23 September 2020  
Our Ref: 19SYW0027  
Your Ref: SSD 10376 & SSD 8876-2

**Sydney Metro**  
**State Significant Development, Development Application (SSD DA)**  
**Issue for Response to Submission**  
**Prepared for Pitt Street Developer South Pty LTD**

**RE: Sydney Metro - Pitt Street South Over Station Development - Response to Submissions (SSD 10376 & SSD 8876-2)**

Figure 2-2: South OSD Loading Dock (reference: Bates Smart)

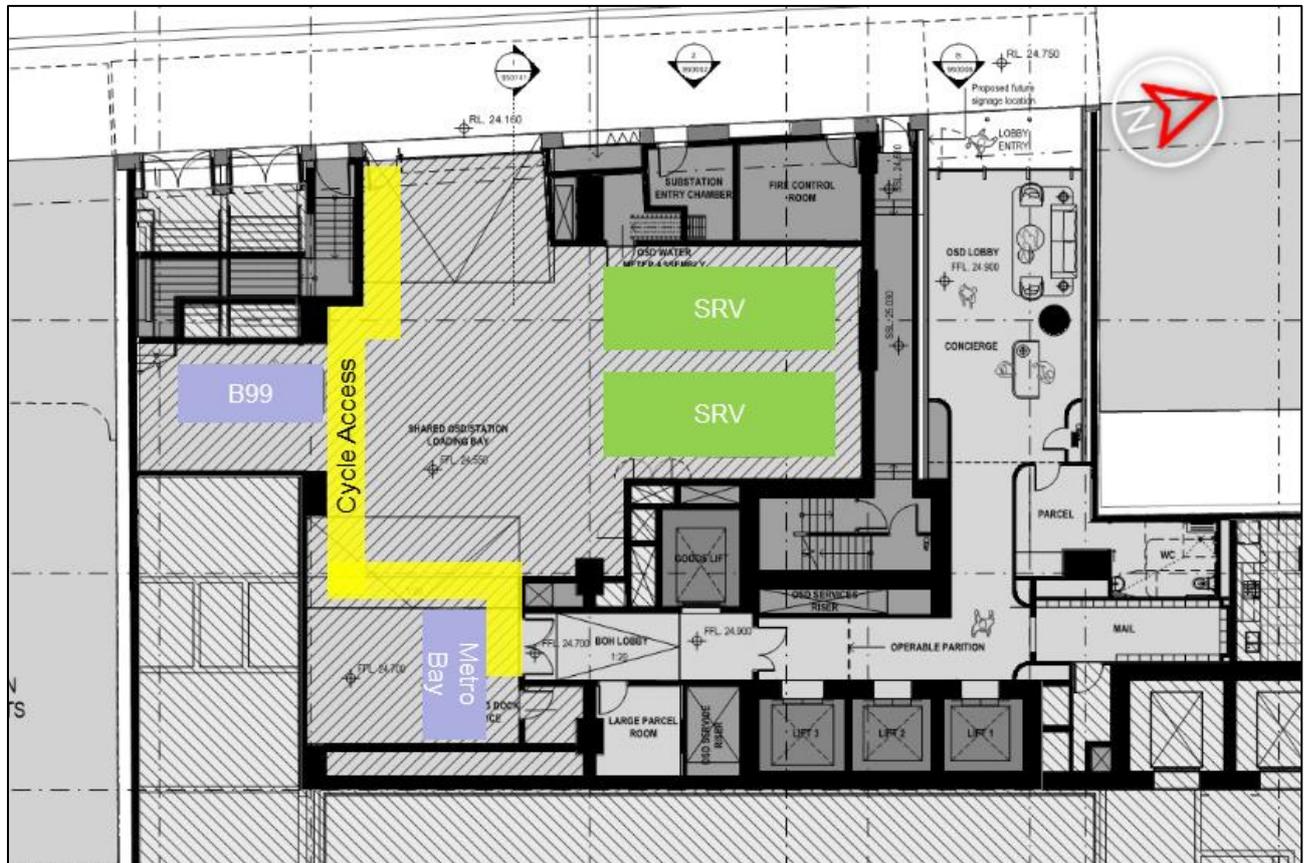
- a) *The site proposes residential uses and must accommodate a Council waste truck. However, the height restriction of the proposed driveway is 2.6m which prohibits council collection. The City requires clearance height for access by collection vehicle to be no less than 4m at any point if the vehicle is required to enter site to service bins.*

Confirming the proposed shared loading dock for Pitt Street South OSD has a clearance height of 3.5m. The proposed height clearance has been developed to meet architectural design objectives including input from all consulting disciplines. Reference should be made to Appendix D, Architectural Plans and all relevant design reporting.

The design vehicle has the following dimensions, Length of 9.25m, height of 3.8m. Notwithstanding the height clearance required the council design vehicle was considered and tested within the proposed loading bay design and found to be too long to manoeuvre within this space. Due to these manoeuvring restrictions on larger collection vehicles, TTM has propose use of smaller collection vehicle (SRV) with a max length 6.45m

The SRV sized collection vehicles are able to operate under 2.5m height clearance and are therefore not affected by the loading bay entry clearance of 3.5m. Based on the information outlined above, it is recommended the site utilises a private contractor with the appropriate dimensioned vehicle in lieu of the City of Sydney's collection contractor.

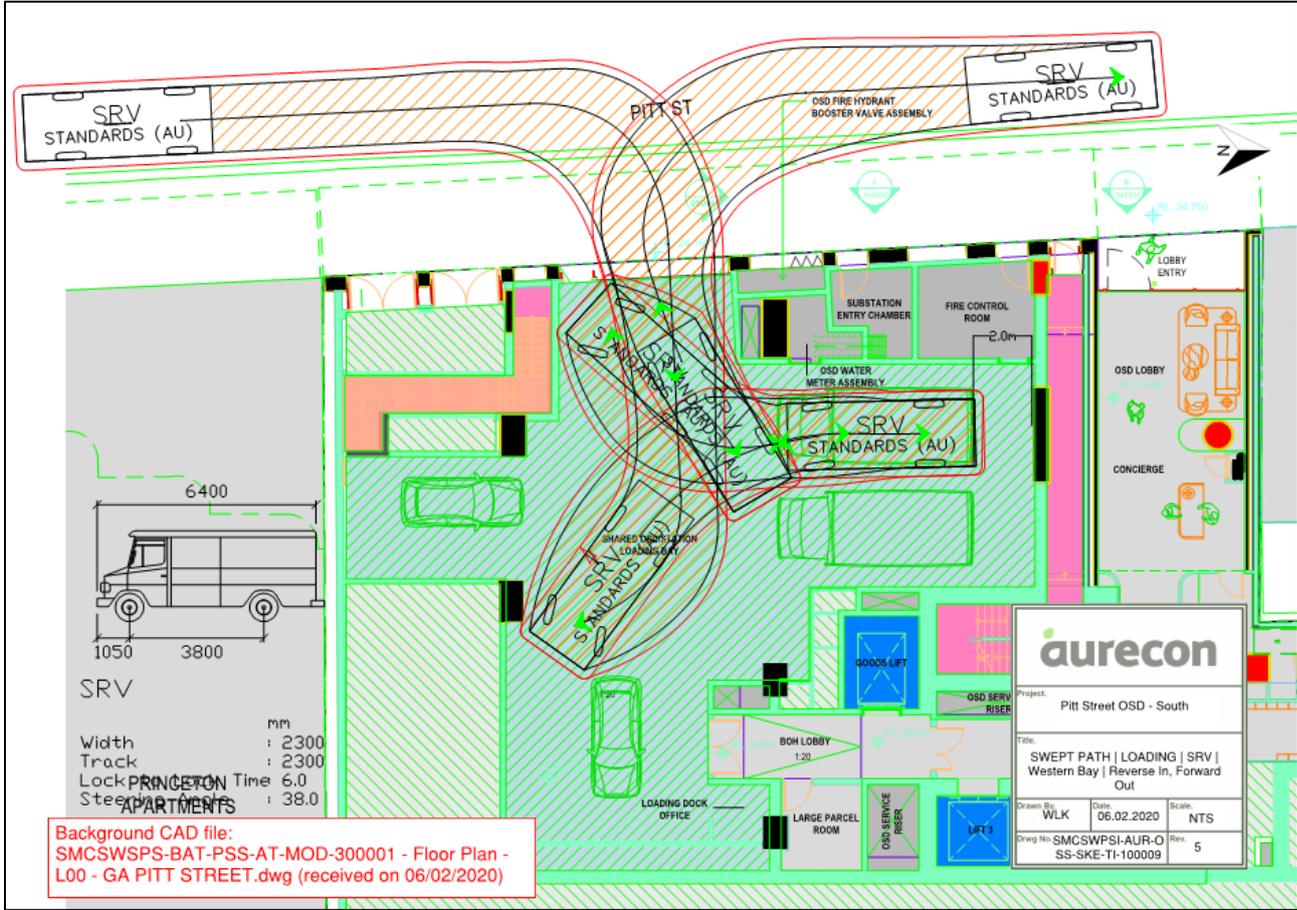
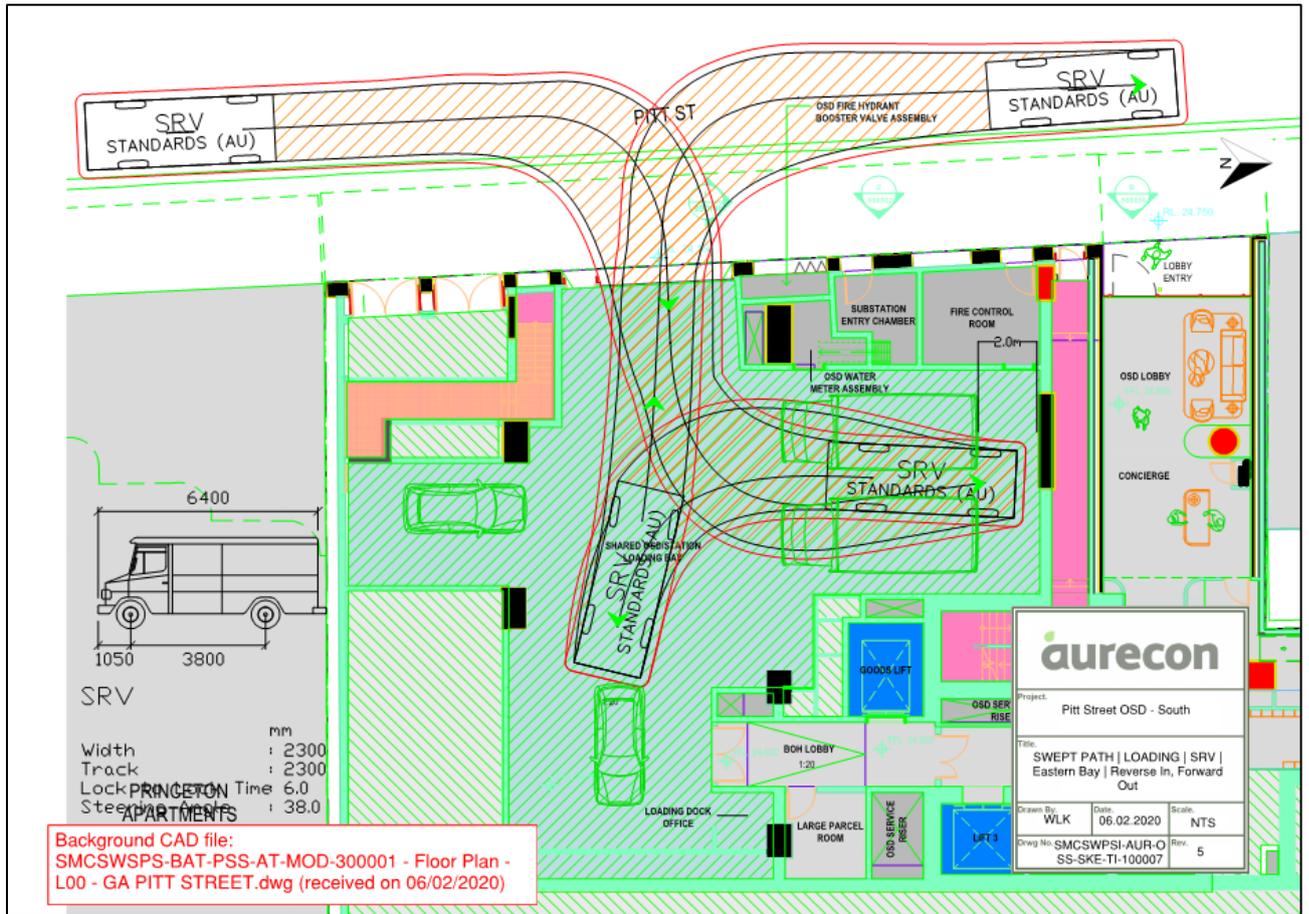
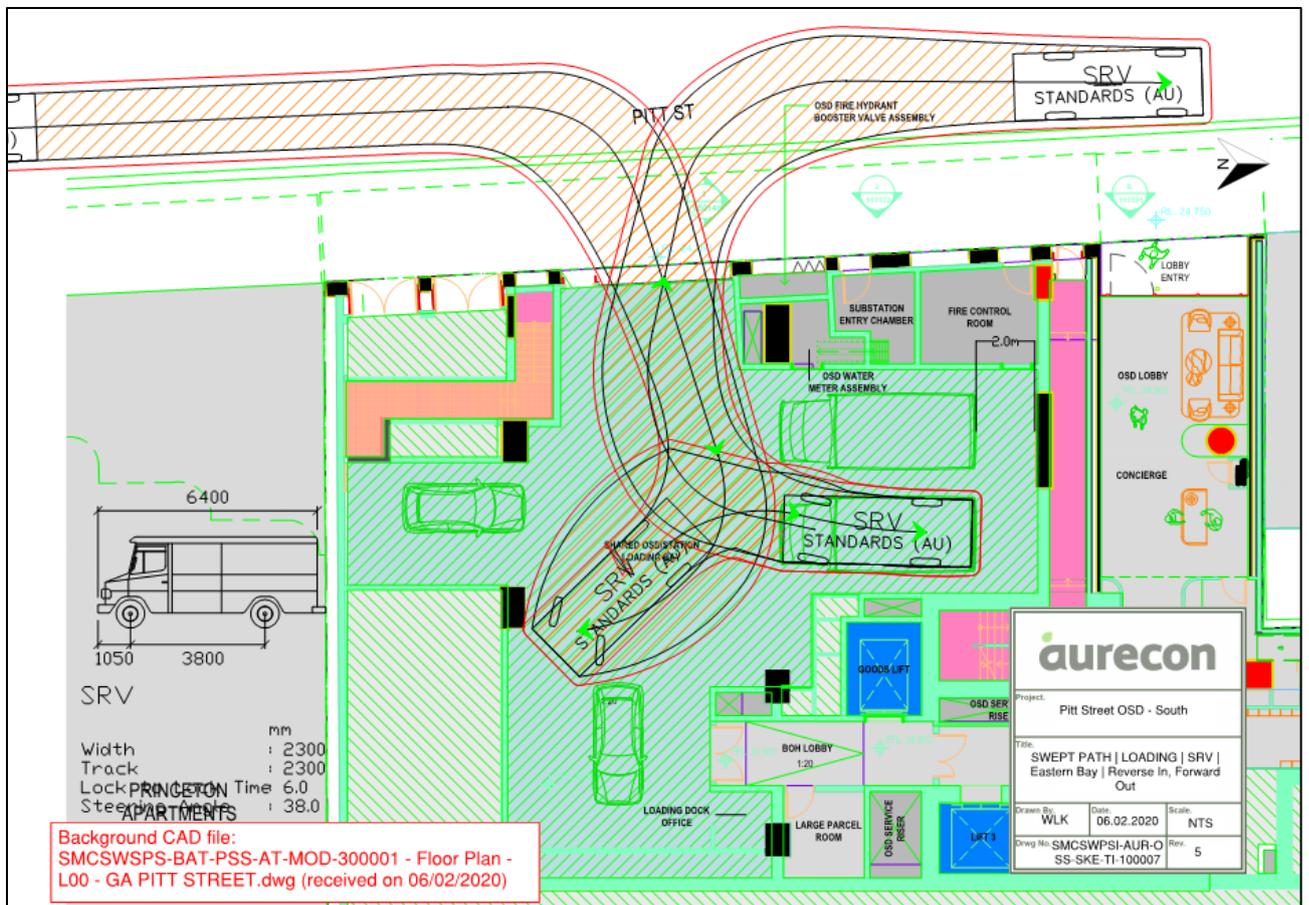
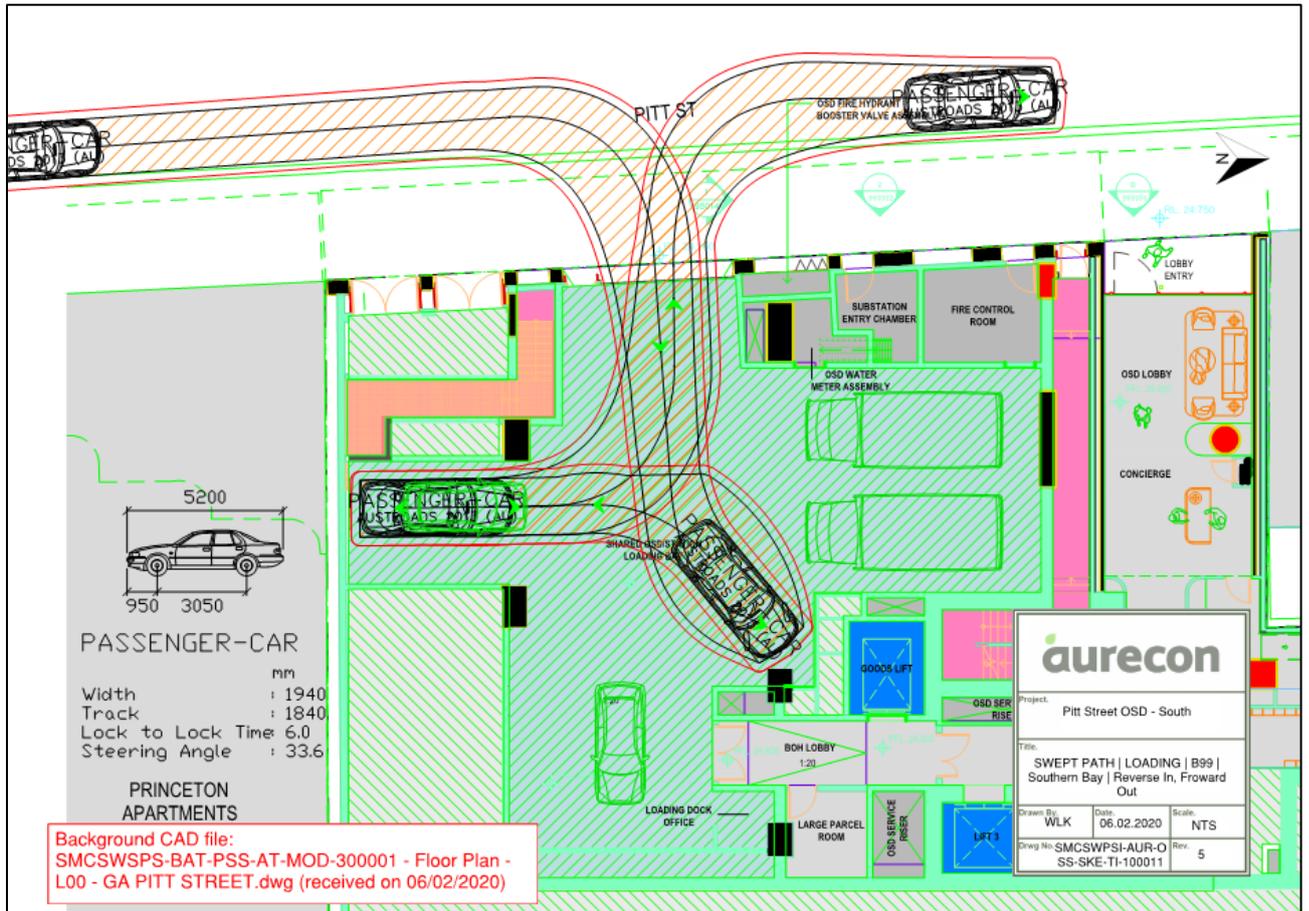
- i. *One loading bay is for exclusive use of Metro.*
- ii. *The Swept Path Analysis does not demonstrate clearly the ability for the site to accommodate two SRVs simultaneously – particularly if a garbage truck is using the site – then only one other bay is accessible.*

**Item b) ii)** - The loading dock will be managed by an onsite loading dock manager and refuse collection vehicles will be assigned a timeslot for attendance for each refuse stream. The timing of each refuse collection vehicle attendance will coincide with low traffic and pedestrian periods allowing for the entire loading bay area to be utilised including transfer and temporary placement of bins within the loading area from Level 1 (OSD South) for collection.
